SUBJECT: **NW 23 Permit Modification Request** for the replacement of Bridge No. 122 over Sandy Creek and Bridge No. 217 over a tributary to Sandy Creek on SR 1116 in Durham County, Federal Project No. BRSTP-1116 (4), State Project No. 8.2353001, Division 5, T.I.P. No. B-3450.

Reference: USACE 404 Nationwide 23; Permit Action ID No. 20021134 issued May 17, 2004.

Changes: Addition of curb and gutter to the project area has increased the permanent wetland impacts by 0.03 acres to 0.17 acres, which consists of 0.05 acres of fill and 0.12 acres of mechanized clearing. Revisions were made to the permit and roadway drawings in order to be consistent with new plans.

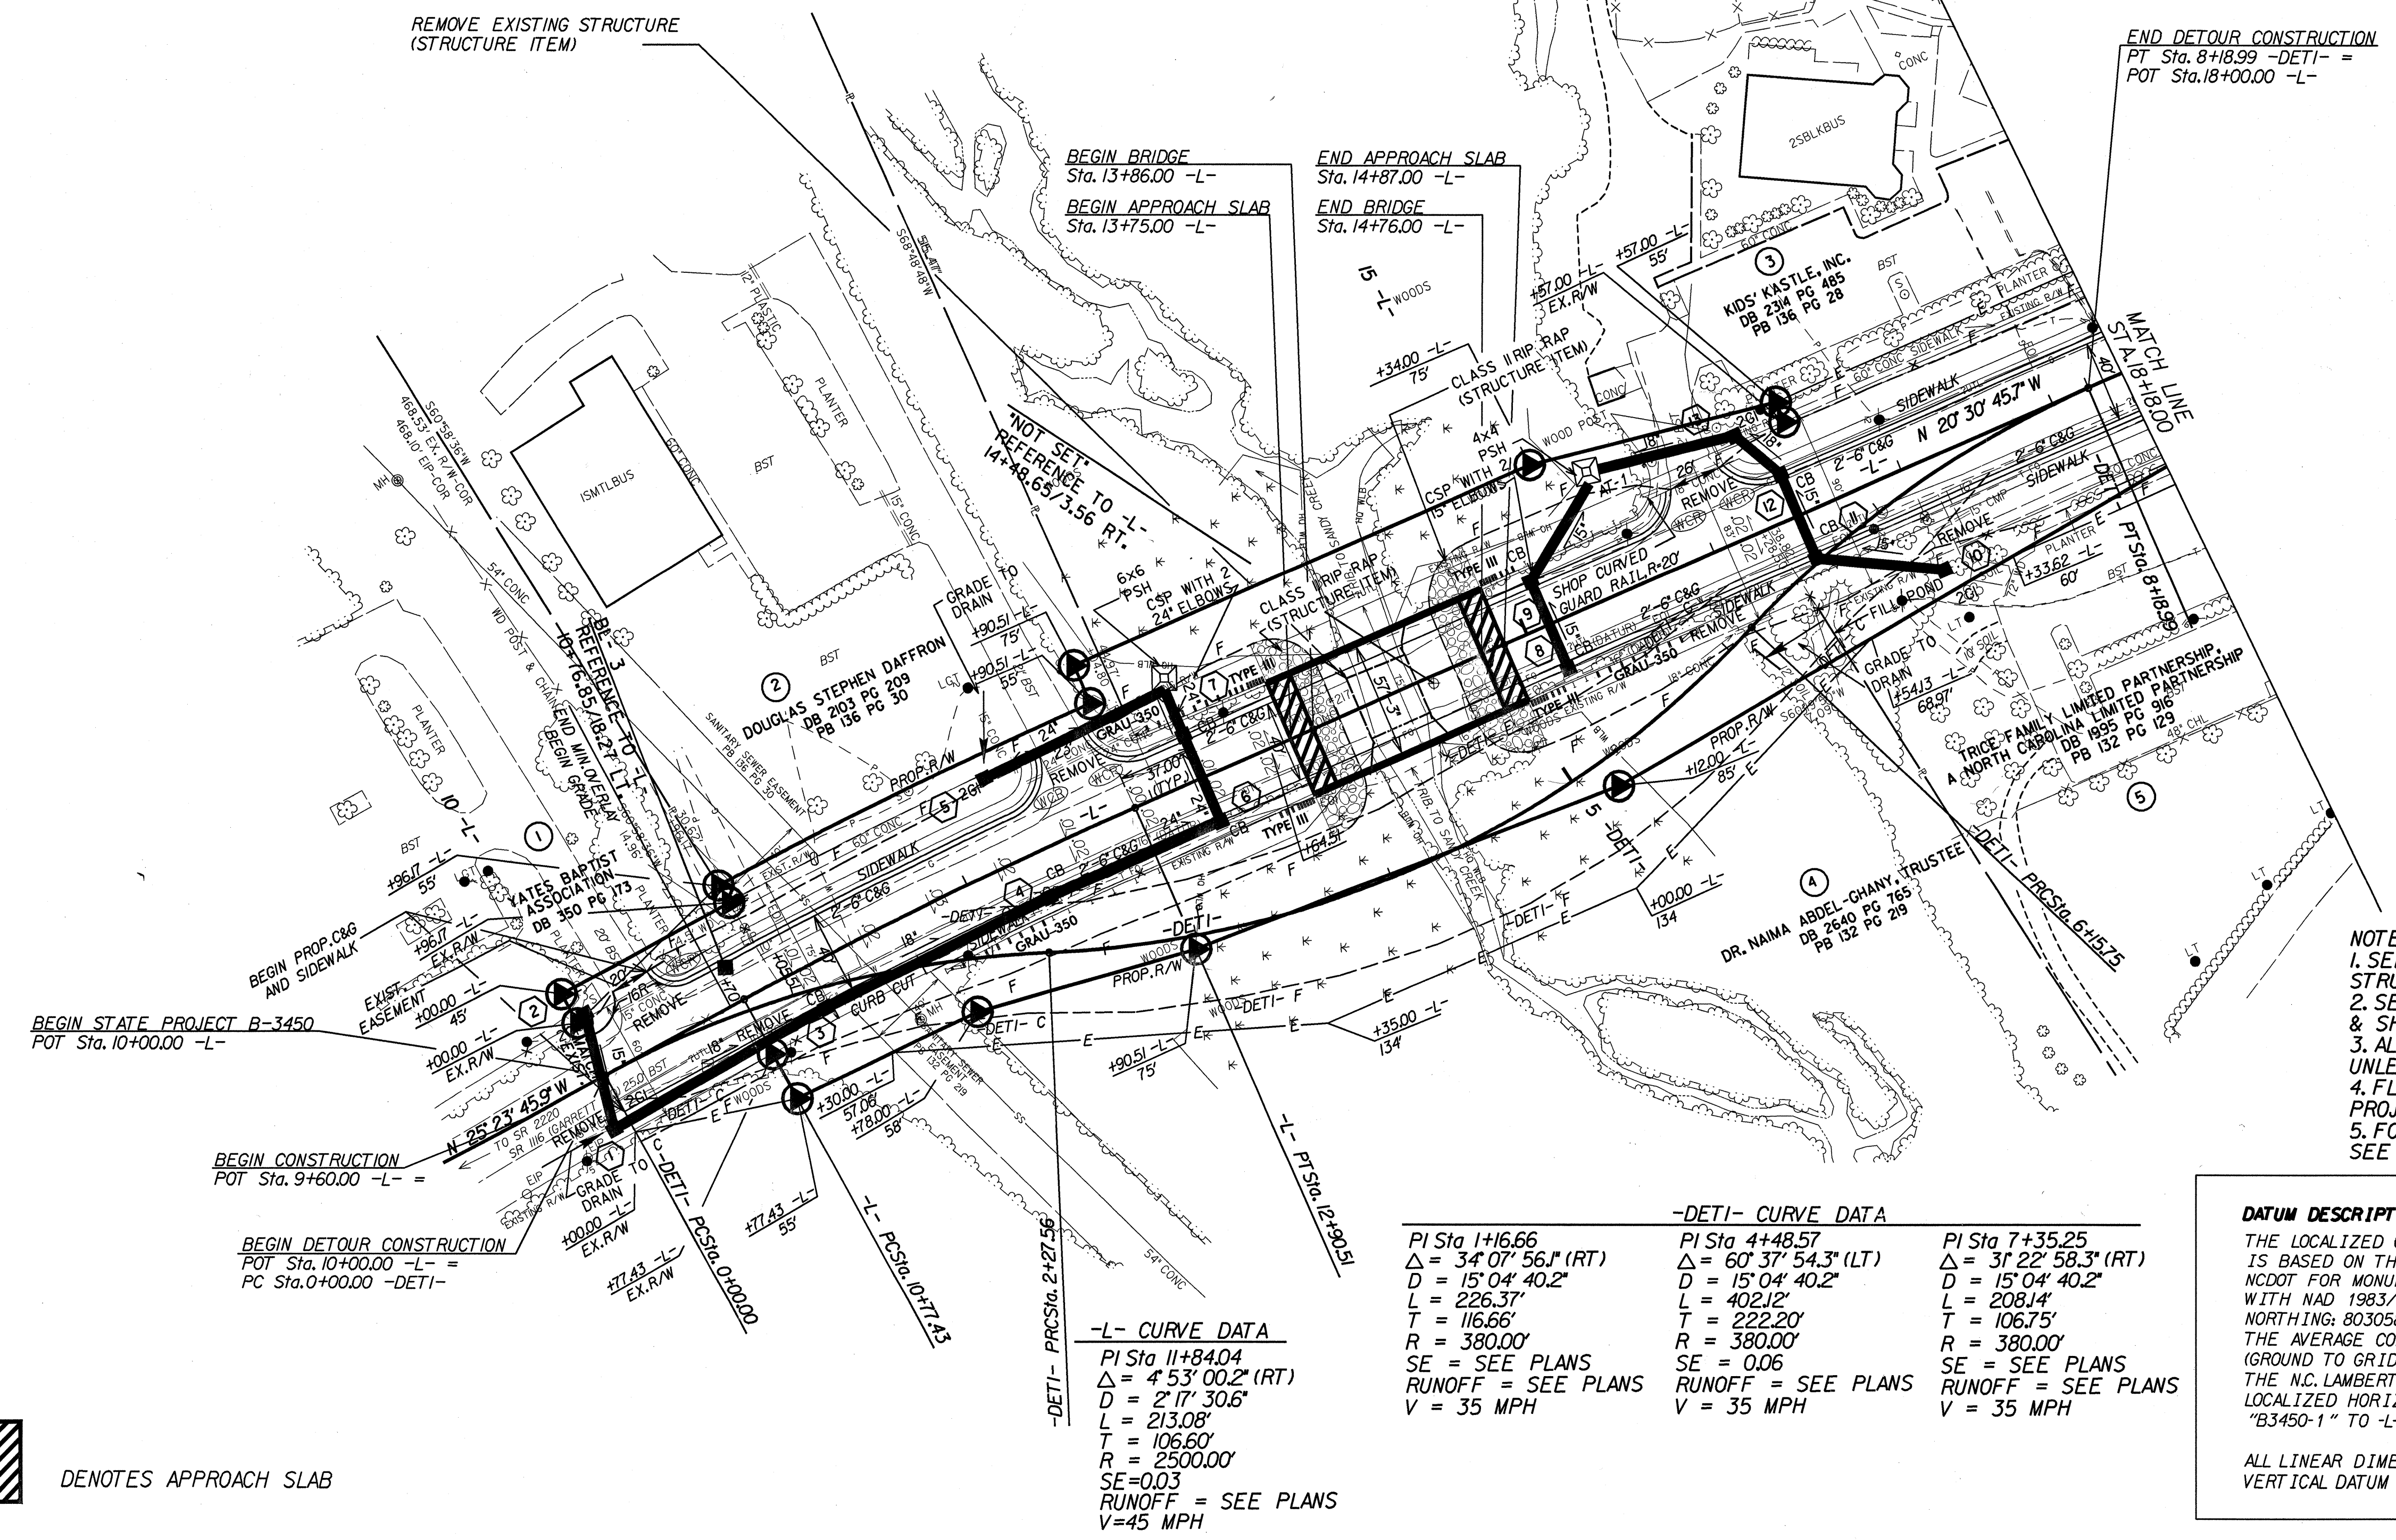
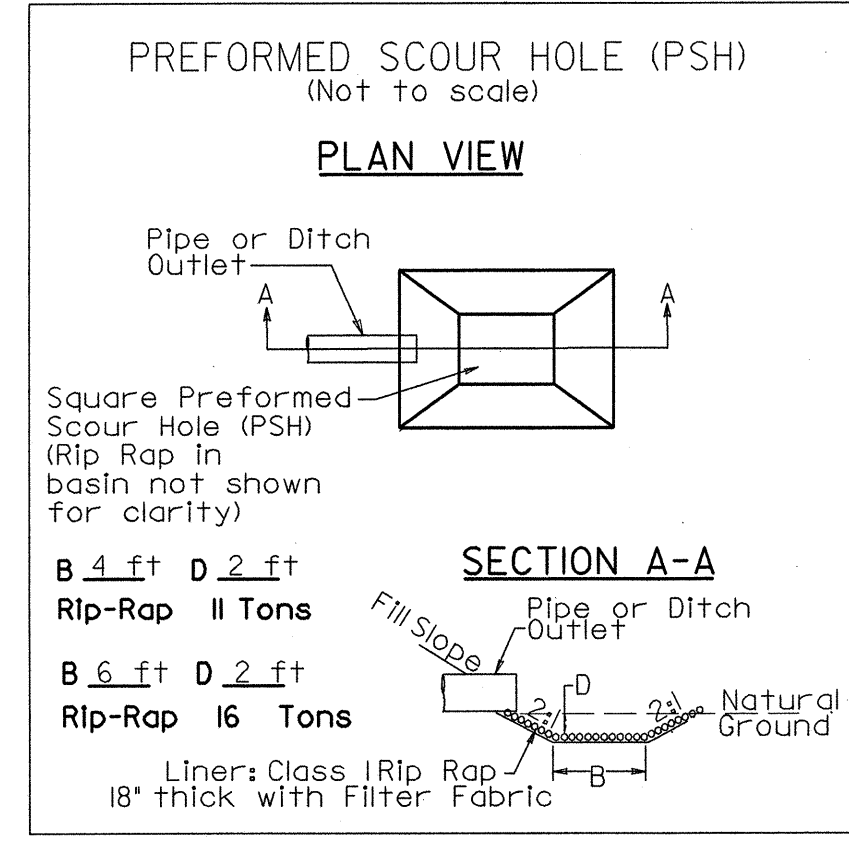
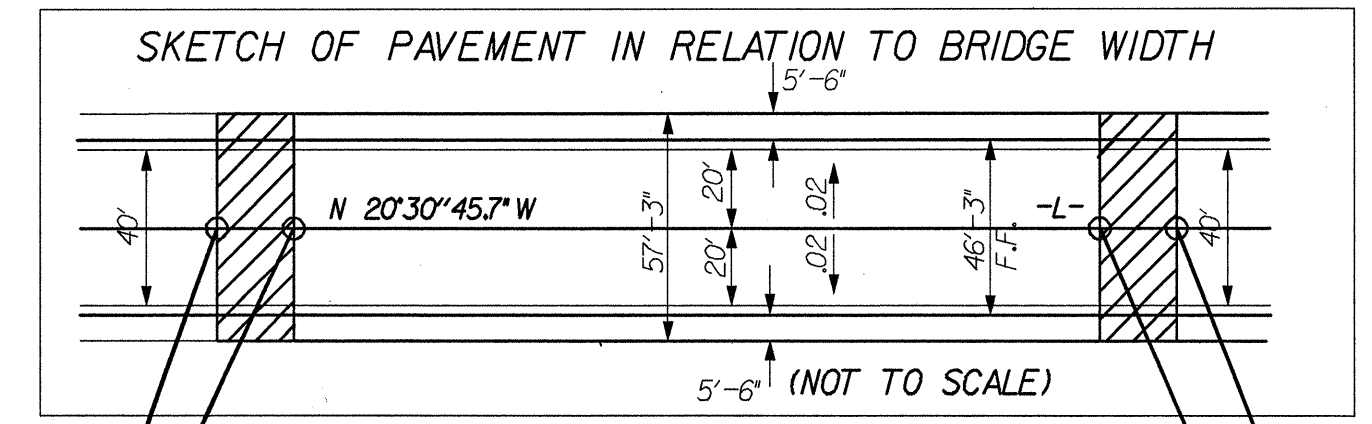
The construction of Bridge No. 217 will require upgrades to the shoulder sections adjacent to the bridge for curb and gutter. The curb and gutter will require an 8-foot shoulder behind the curb for a sidewalk. These additions will impact 0.03 acres of wetland.
